Planning - Case Comments

Project Number: PR-2022-004457

Project Name: Quivira Estates

Final Plat

FINAL PLAT
QUIVIRA ESTATES
 BEING A REPLAT OF TRACT 22, VOLCANO CLIFFS UNIT 6
 AND QUIVIRA DRIVE NW
 SITUATE WITHIN
 SECTION 21, T. 11 N., R. 2 E., N.M.P.M.,
 CITY OF ALBUQUERQUE
 BERNALILLO COUNTY, NEW MEXICO
 MARCH, 2023

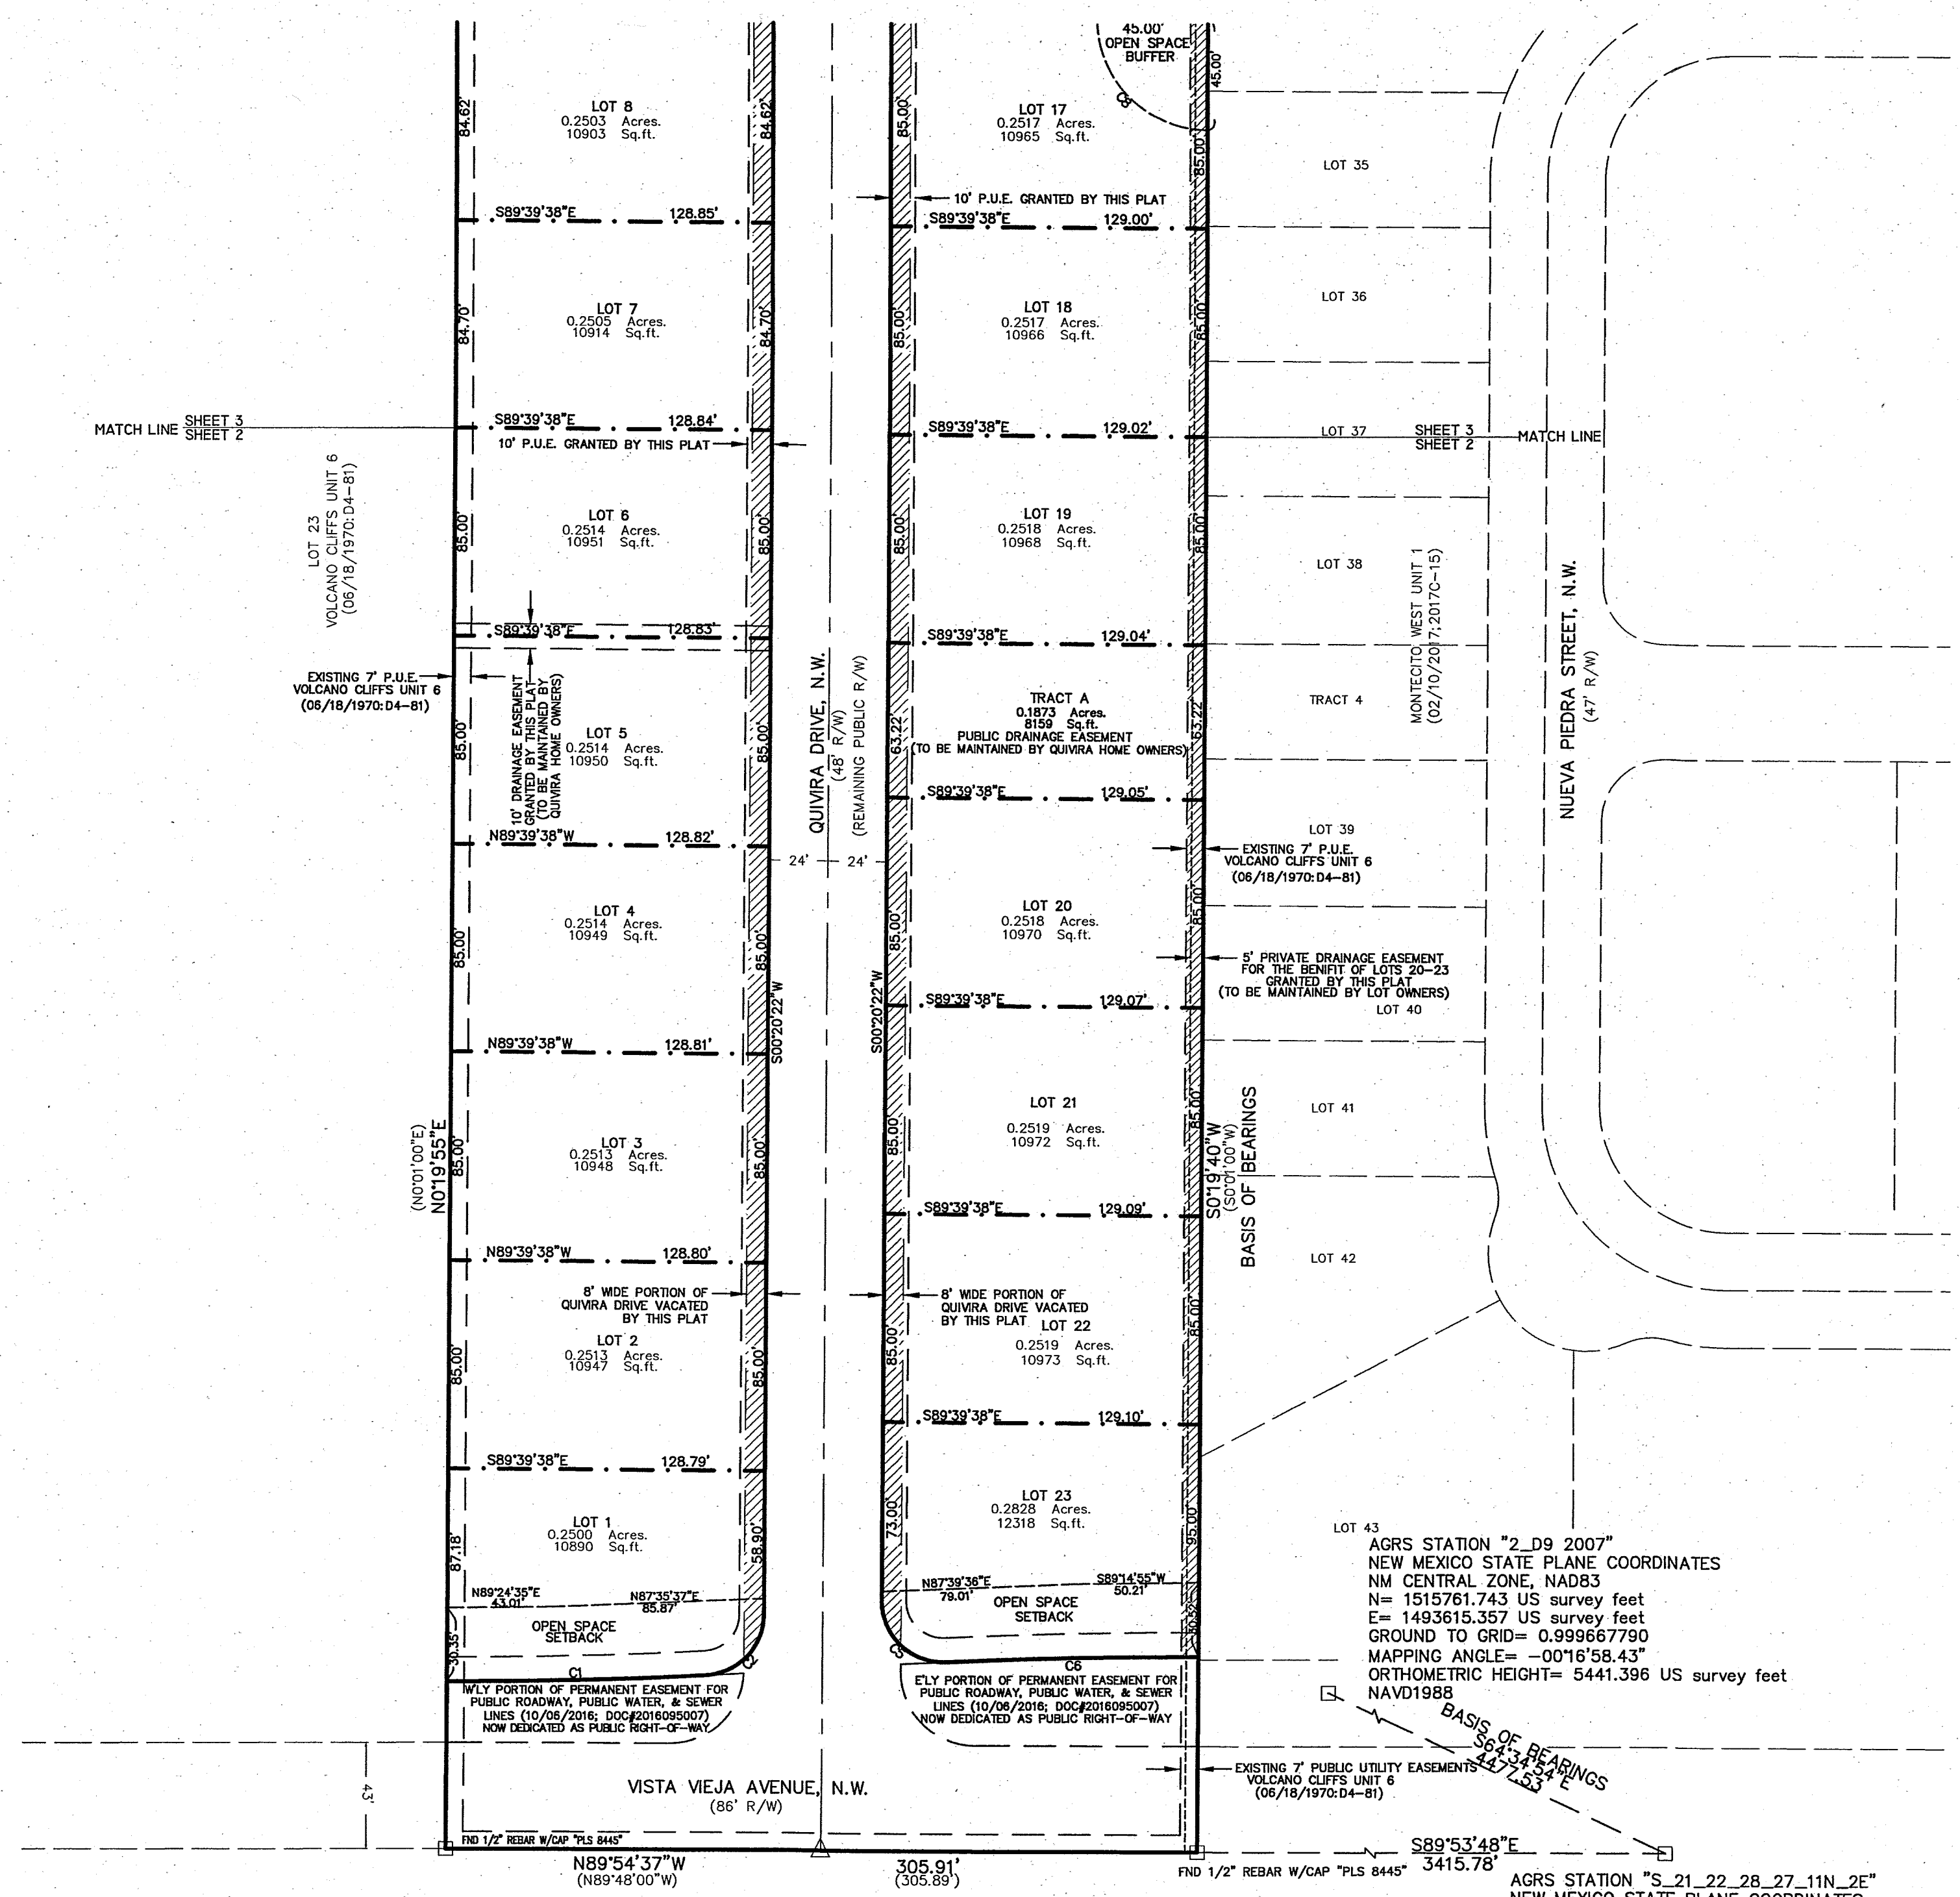
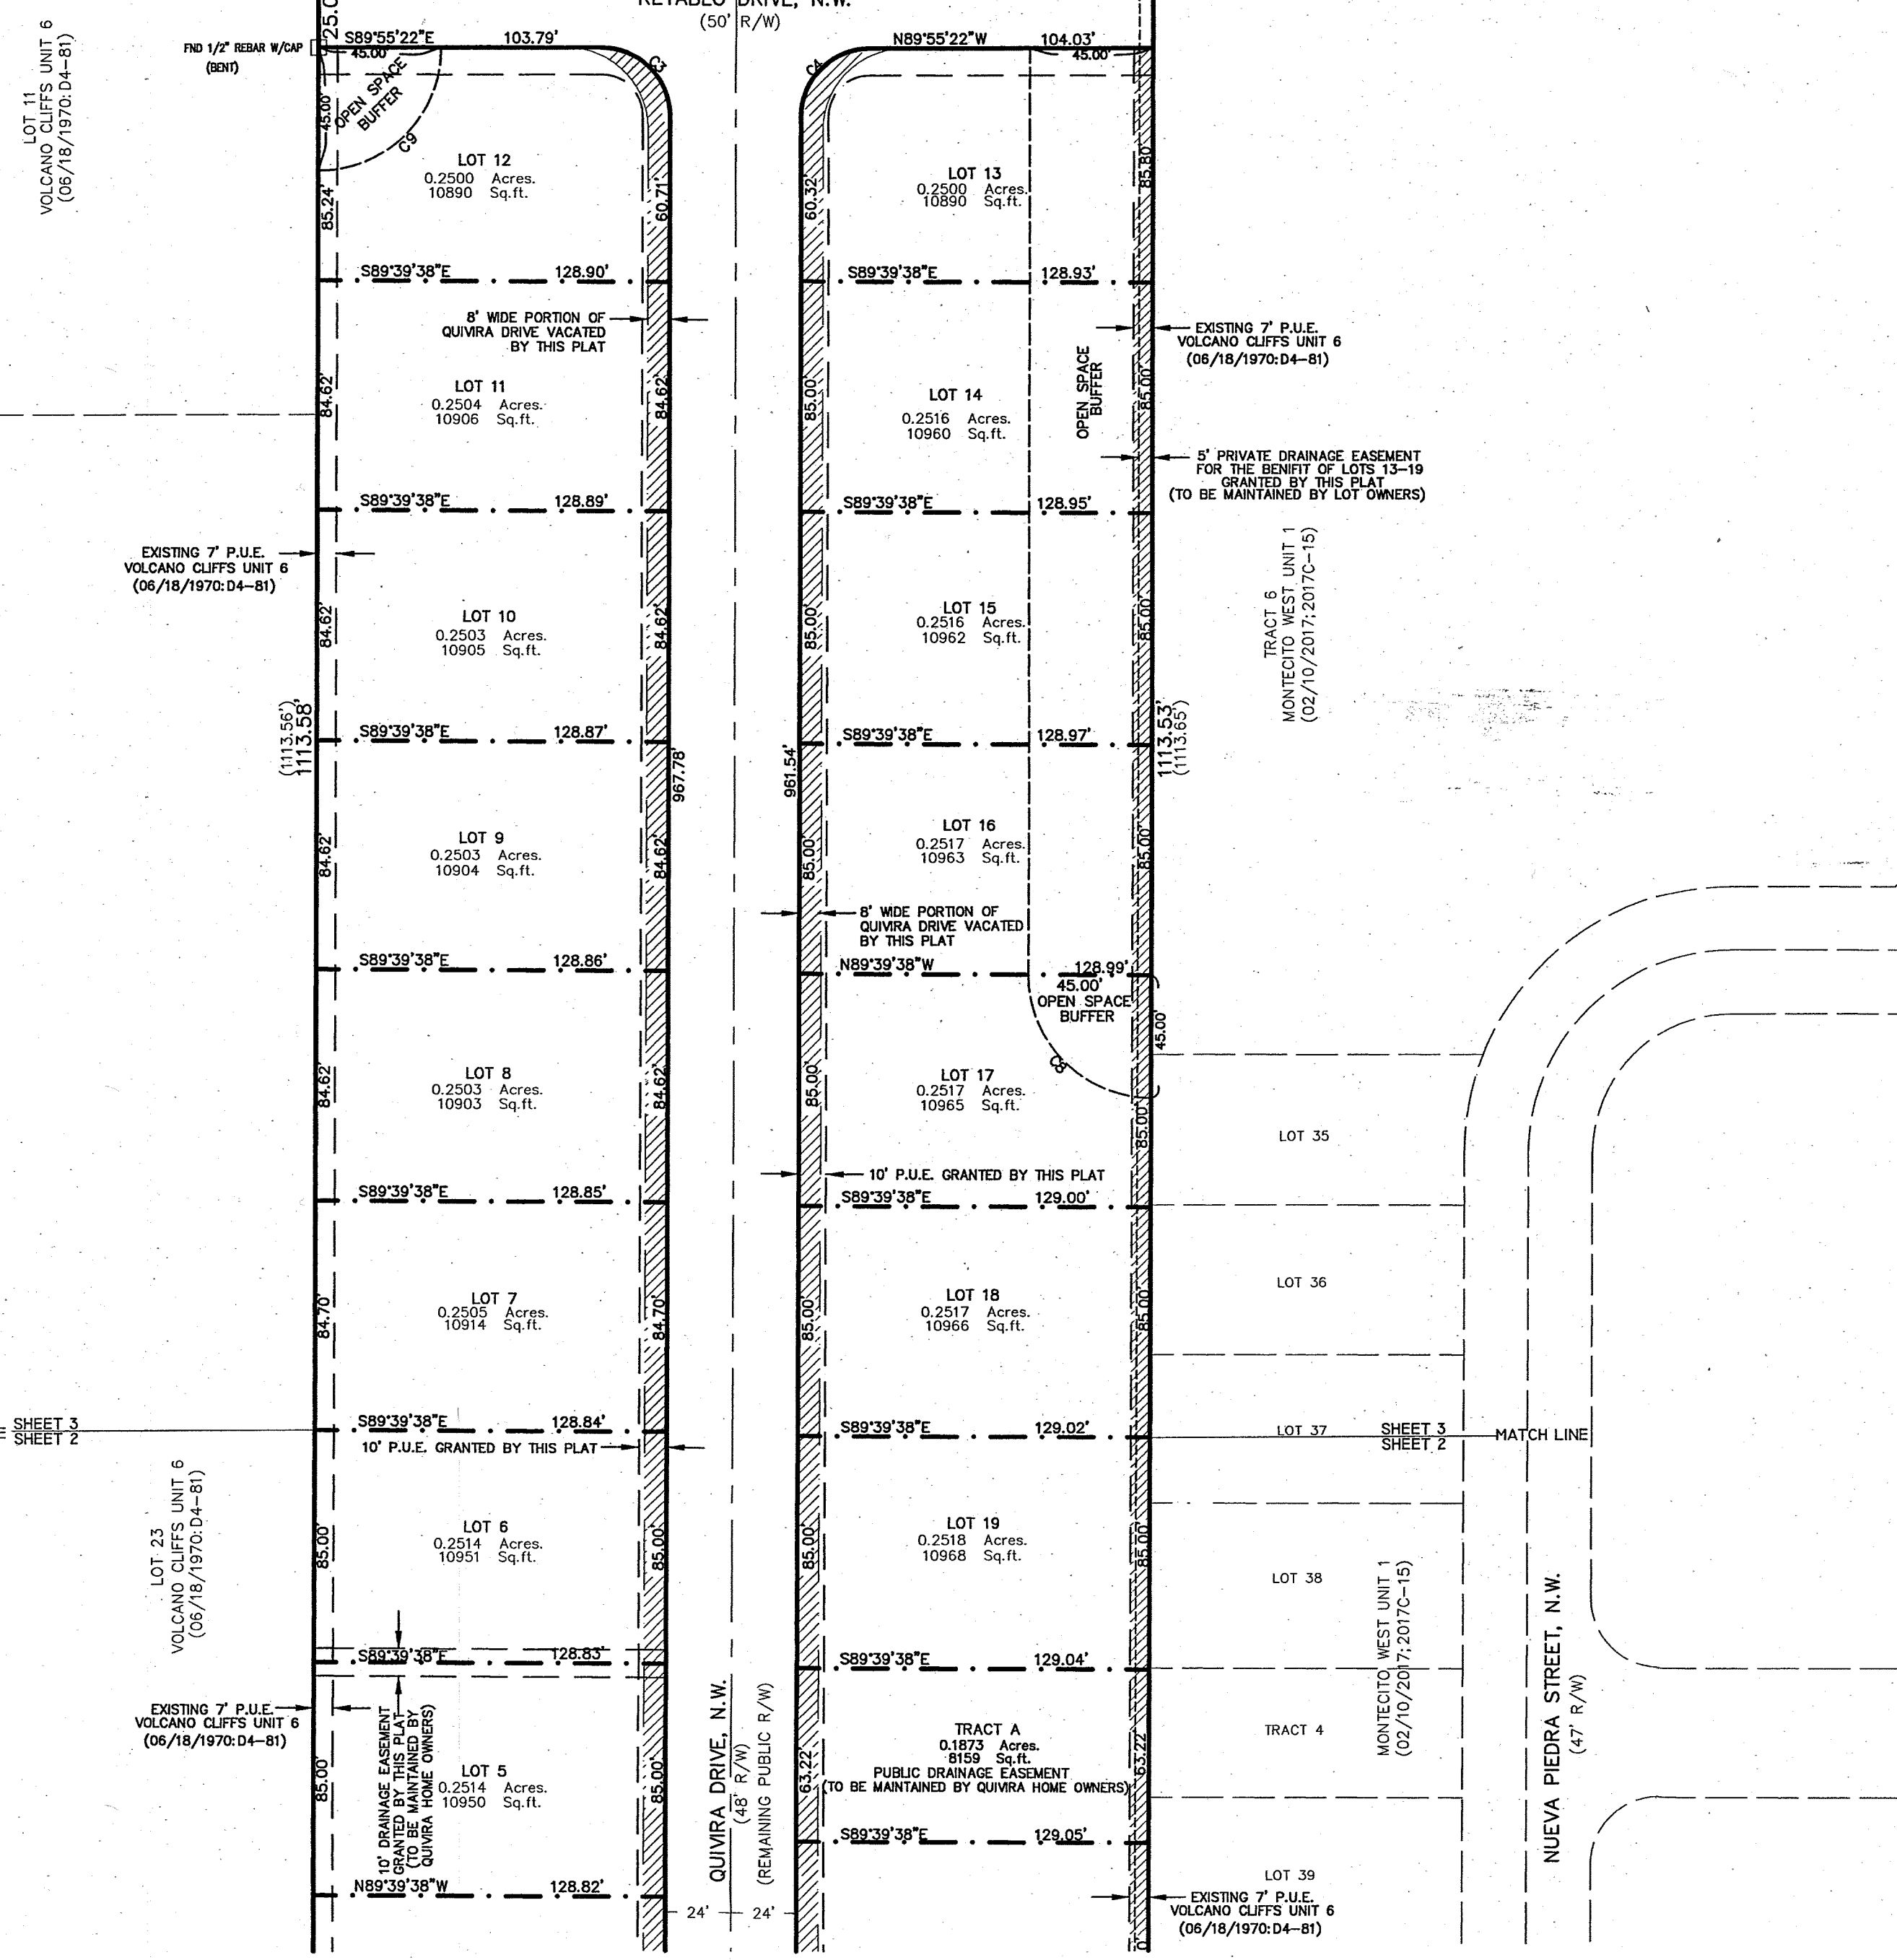
- Planning defers to Parks and Recreation regarding the approval of landscaping within the 45-foot open space buffer and setback that encroaches on portions of Lots 1, 12-17, and 23.
- Please explain why the lot at the southeast corner of the subdivision has a buffer area that is substantially lower than the lot itself. What is the vision for landscaping this area to be landscape buffer with the finished pad above it?
- Please provide an explanation regarding the change of 7-foot private drainage easement called out on Lot 20 to a 5-foot private drainage easement.

- ABCWUA must verify that the pro rata was paid prior to the approval of the Final Plat.
- The project and application numbers must be added to the Plat prior to final sign-off by DFT staff, should the Plat be approved by the DHO.

- Older DRB signature block needs to be replaced with current DHO signature block. Here is the DHO webpage:
<https://www.cabq.gov/planning/boards-commissions/development-hearing-officer>
